Application number: 2024/91008	
What is the application for?:	Variation condition 1 (plans) on previous permission 2023/90909 for reserved mat
Address of the site or building:	adj, 115, Westfield Lane, Wyke, BD12 9LY
Postcode:

Client Yorkshire Choice Homes Limited	
Westfield Lane, Wyke GABION WALL SECTIONS	
Scales 1:1250 1:200 @ A1	Date Feb 23
Drawing Number 2023-018-101	Revision - CON
Drawn by YCHC

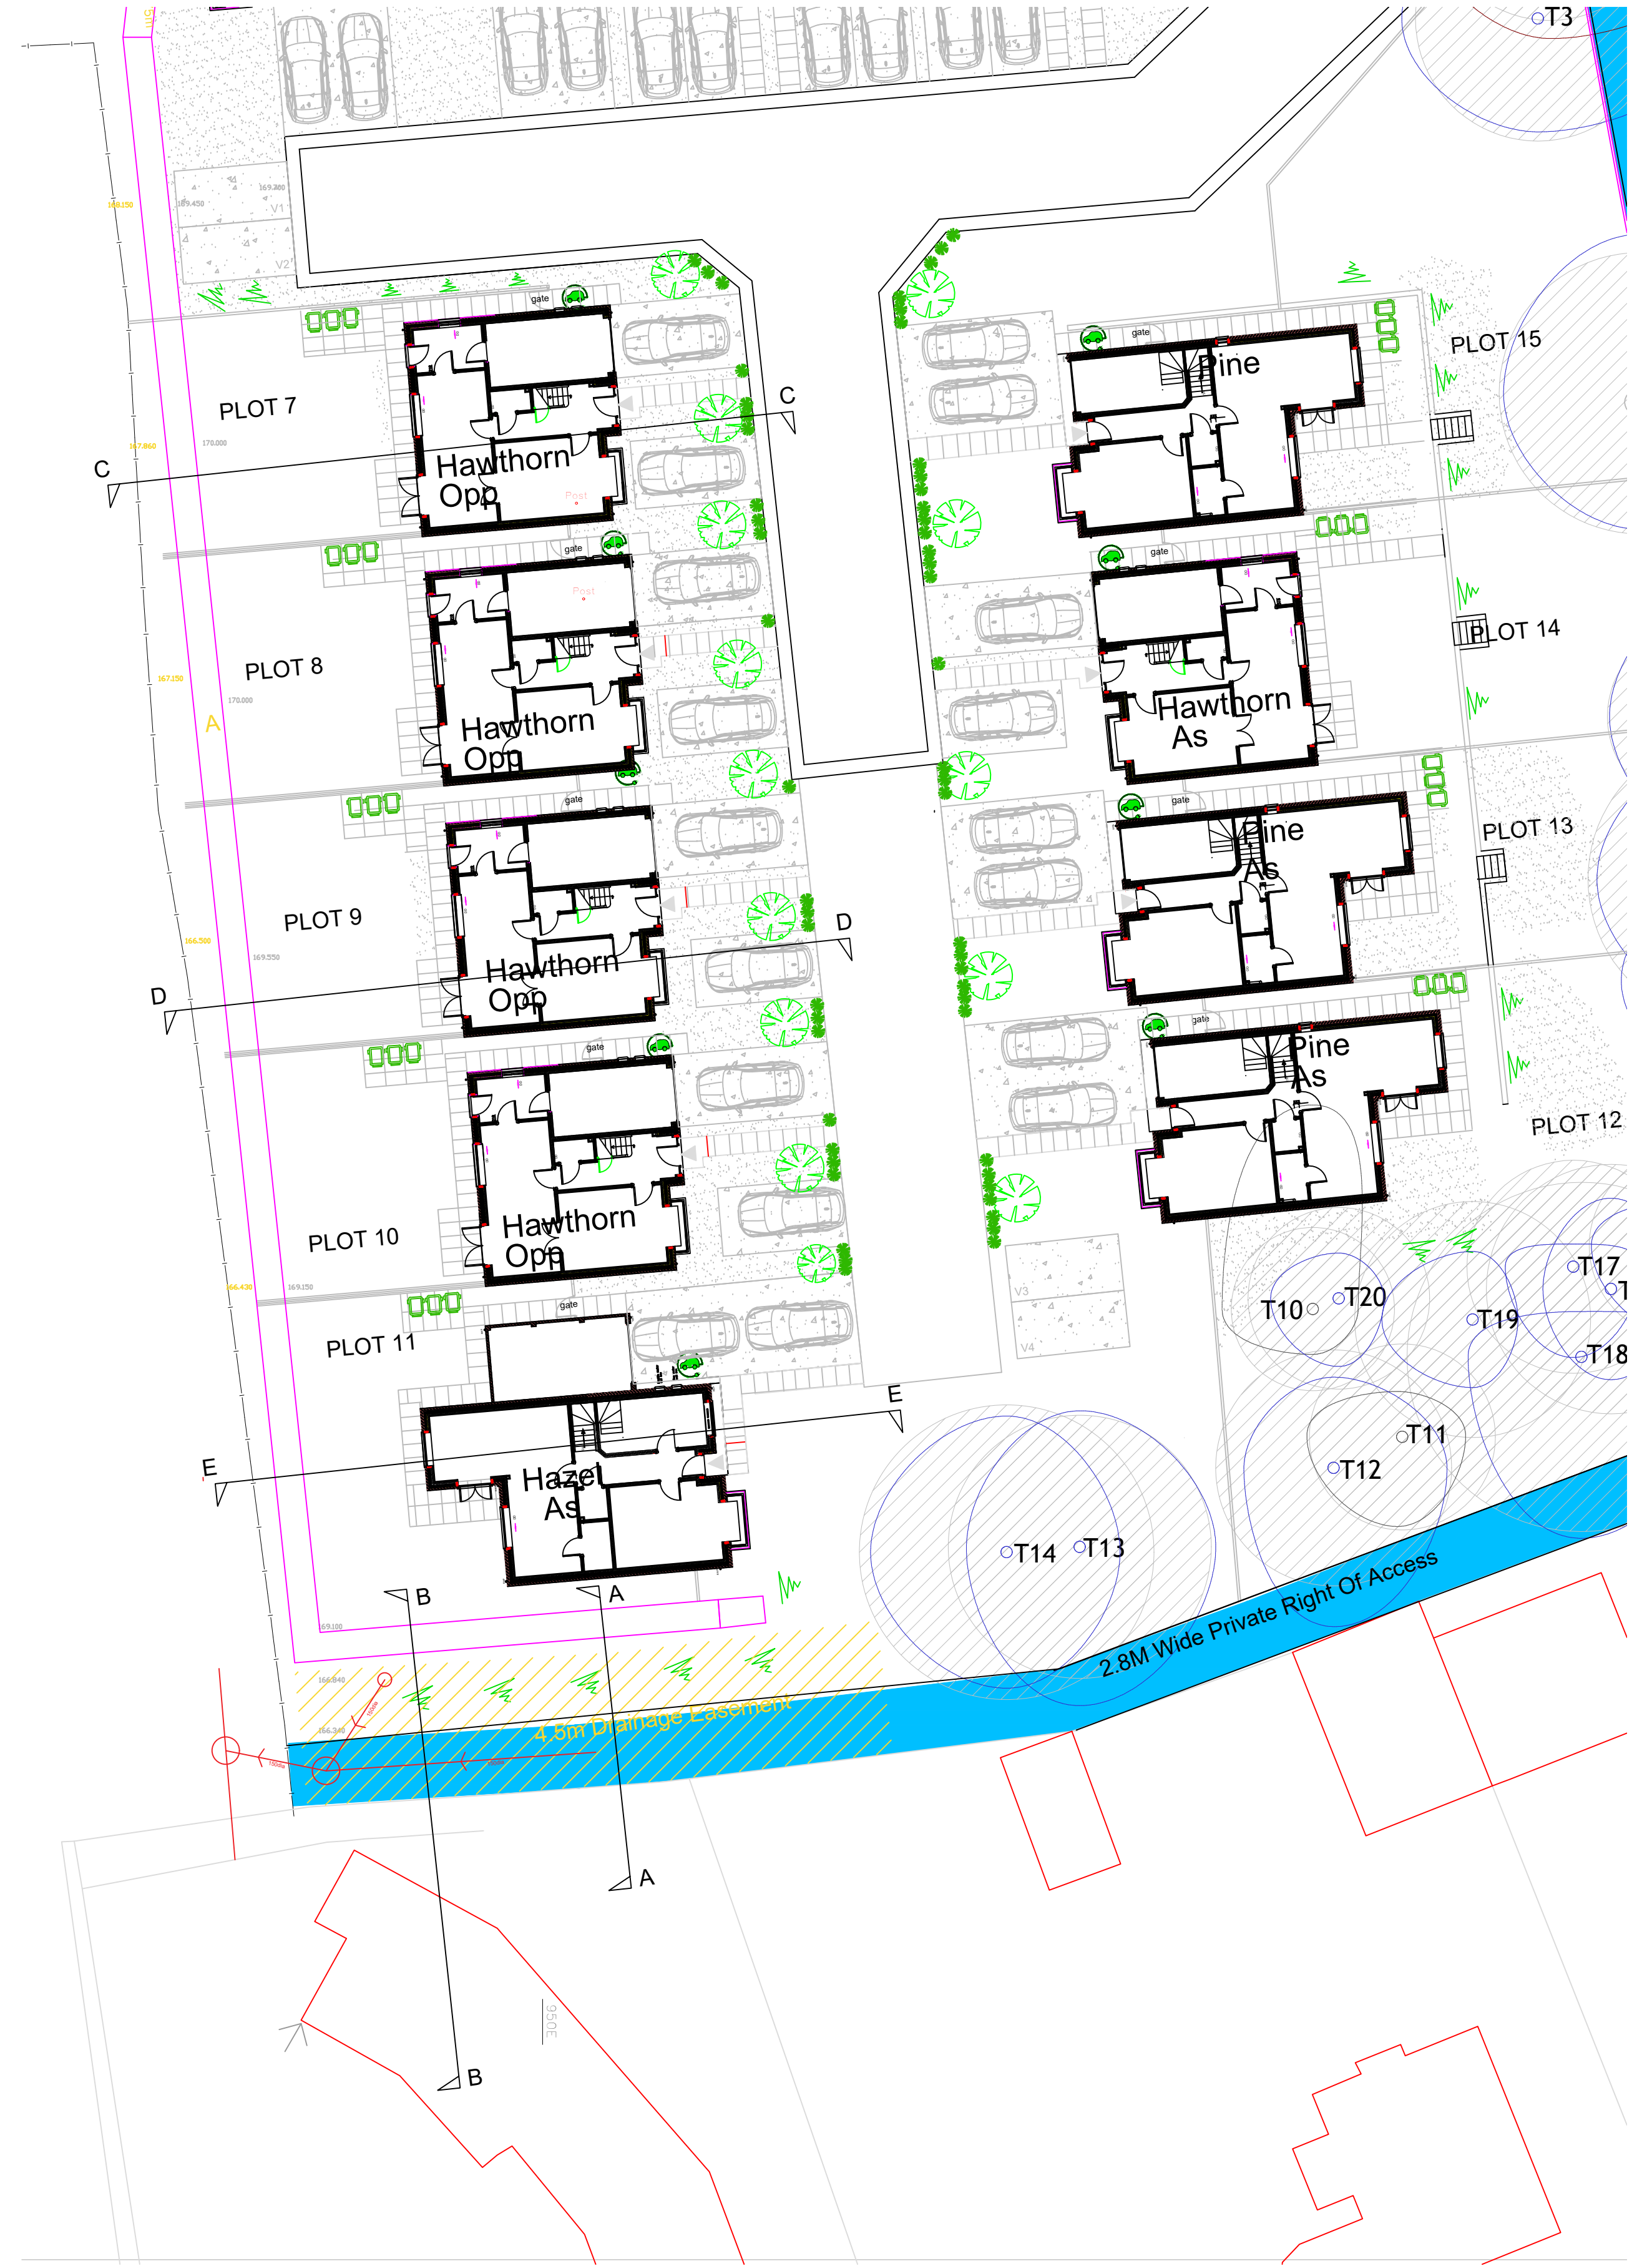
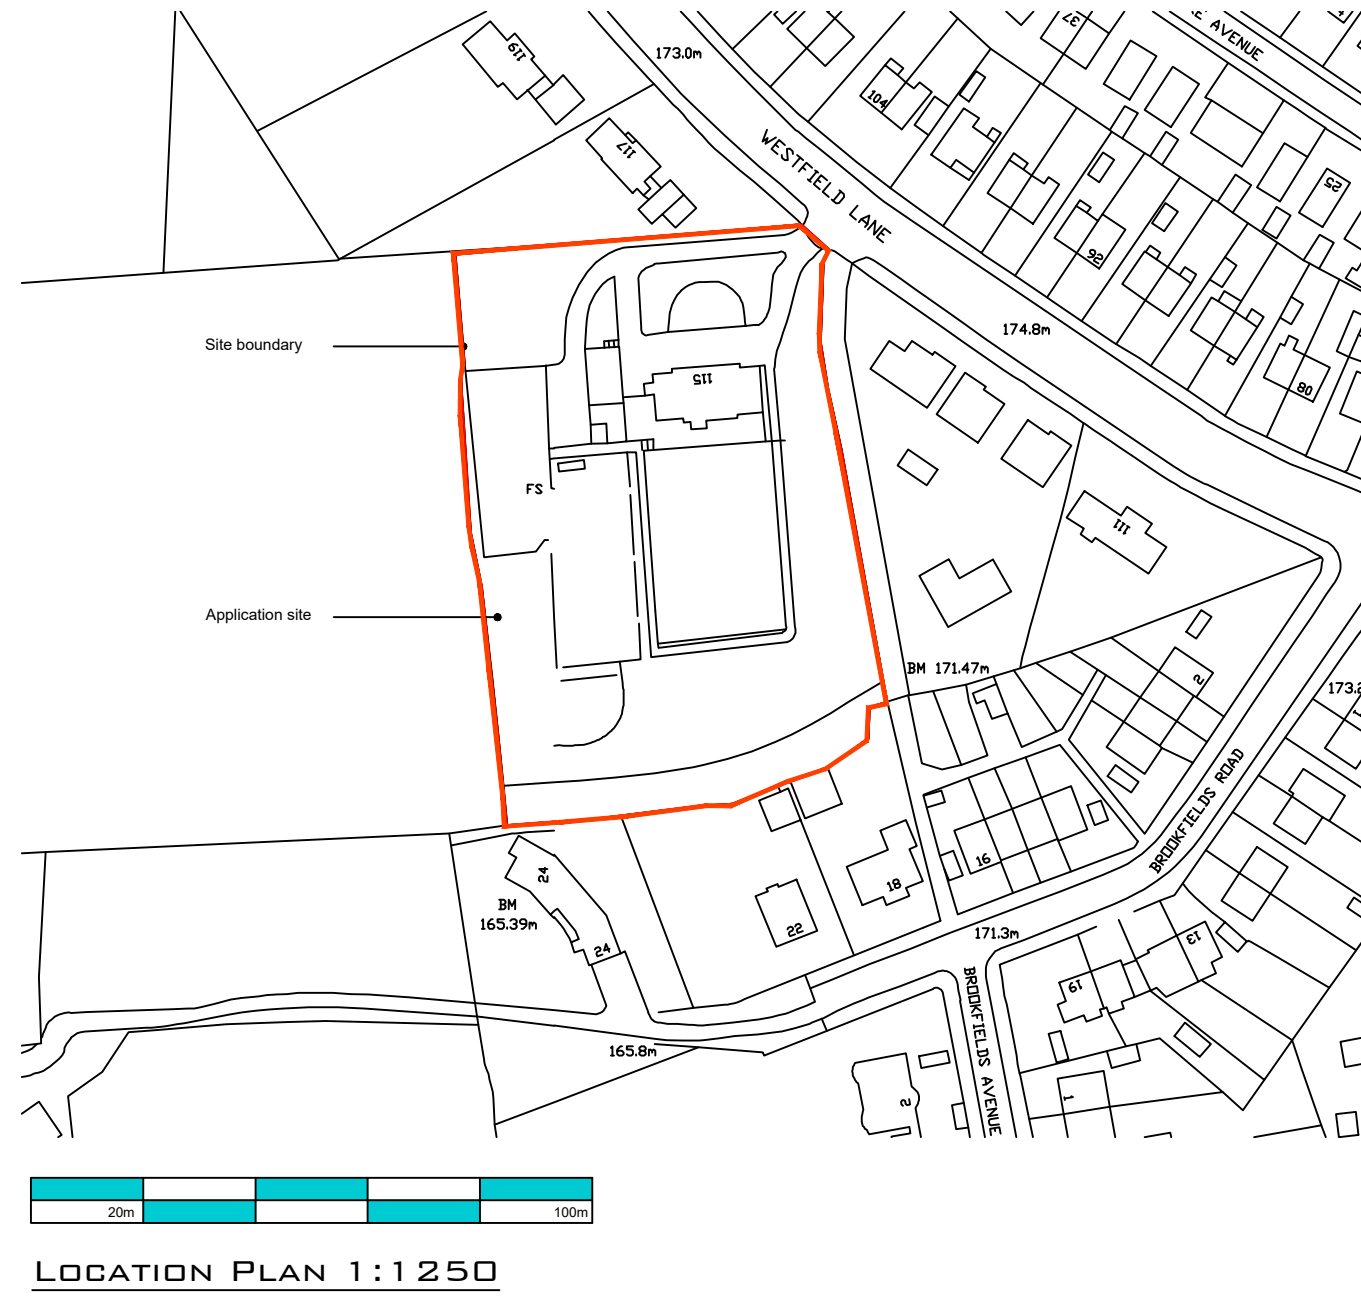
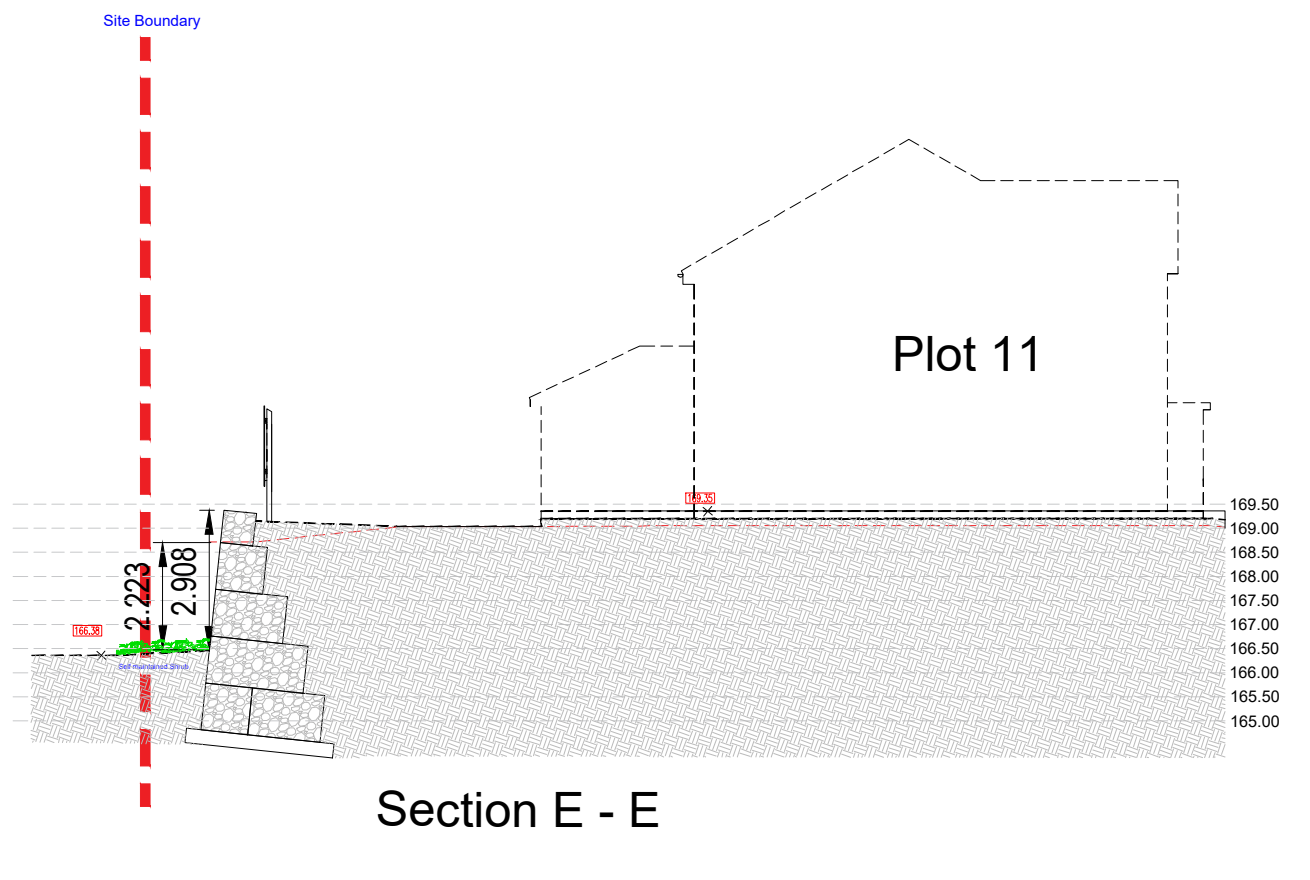
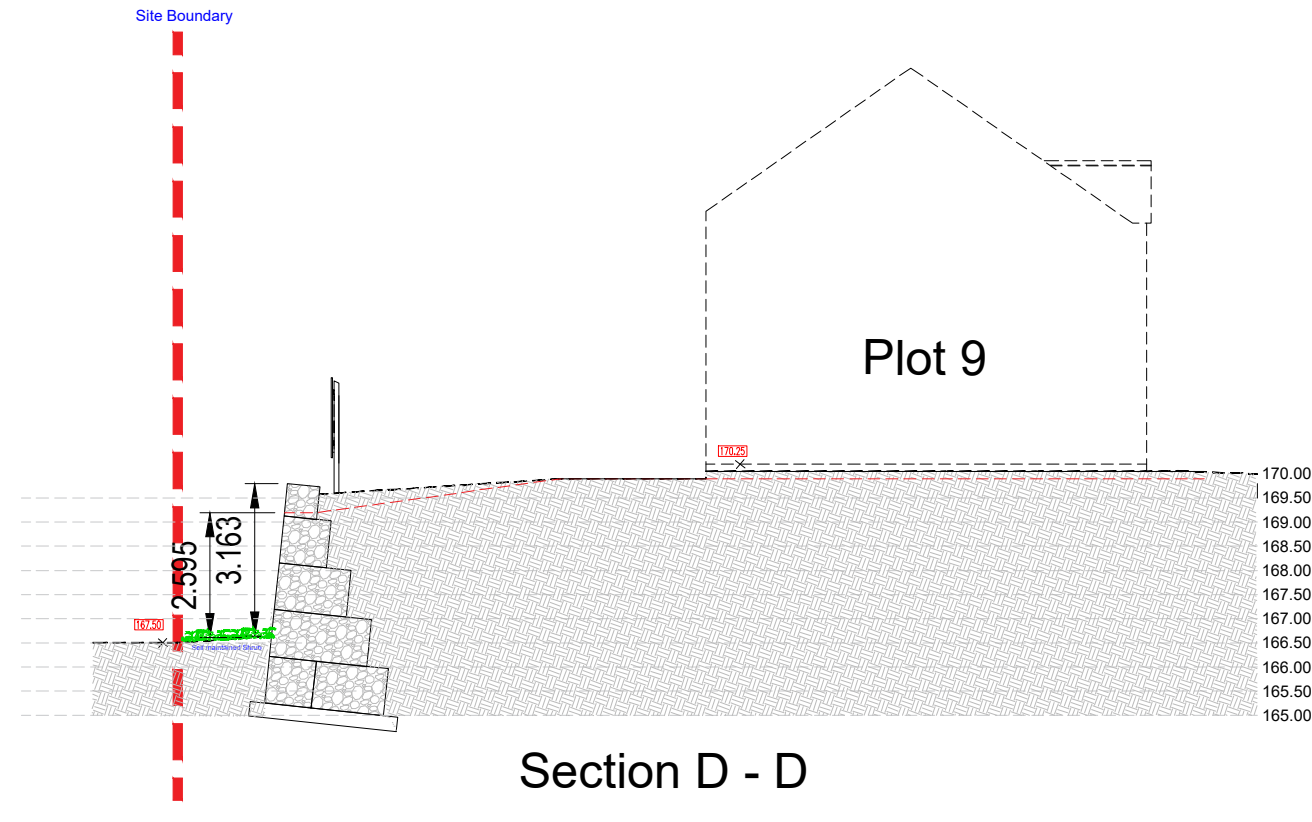
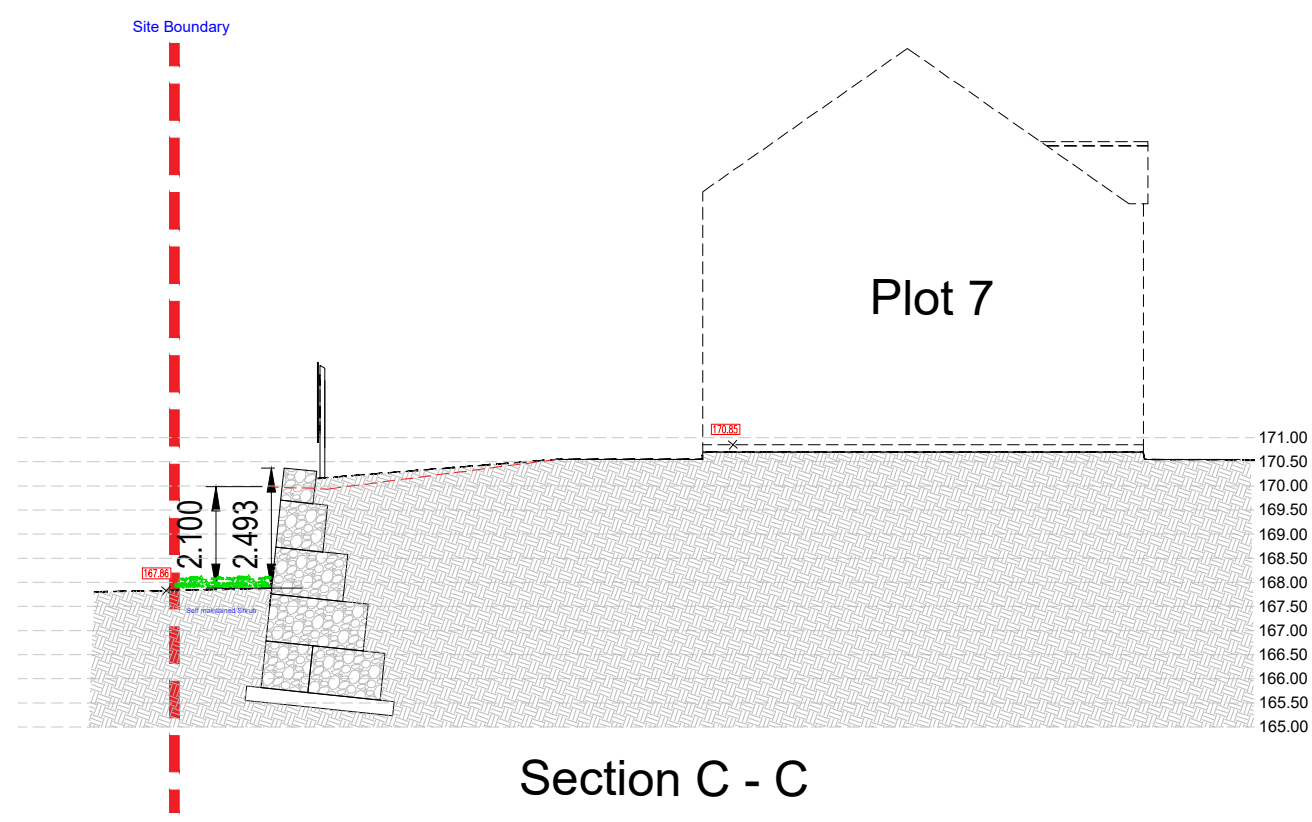
Type of comment: An objection	
Do you wish your comments to be published on the website anonymously?	Yes
May it be noted this is a retrospective application as the wall already built is much higher and much longer then the original plans. Where were building control when this took place? I object to the ammendment for the following reasons: Conservation of the natural environment / effect on trees and the landscape - a 3 metre wall is impassible to ground dwelling wildlife like hedghogs. They can only now access the development via the road. Further trees with TPOs are being removed and "trimmed" in order to "make a better development" these trees were here when orginal plans submitted. Had these "ammendments" been proposed at the start the development would not have been approved. Yet another backhand and backdoor way of getting things passed, shameful Kirklees for approving. Now this T2 tree is considered newly dangerous ? Why ?Damage by construction process. Any follow up / financial implication because of this? On the original application (now confusing due to the sheer number of ammendments and further applications) an environmental impact financial contribution was mandated. Is this still the case? Please address, how much and where being spent and insure this is occuring in Scholes. I object also to design, appearance and layout effect on the character of an area / privacy of neighbours - houses are raised on a 3 metre platform making them equivalent of 4 story house that overlooks neighbours directly. The retaining wall is not in keeping with the landscape. The long left side has no planting planned. And once planted who will maintain as they will have to use other peoples property to access as this cannot be accessed from inside the development due to the 3m drop.
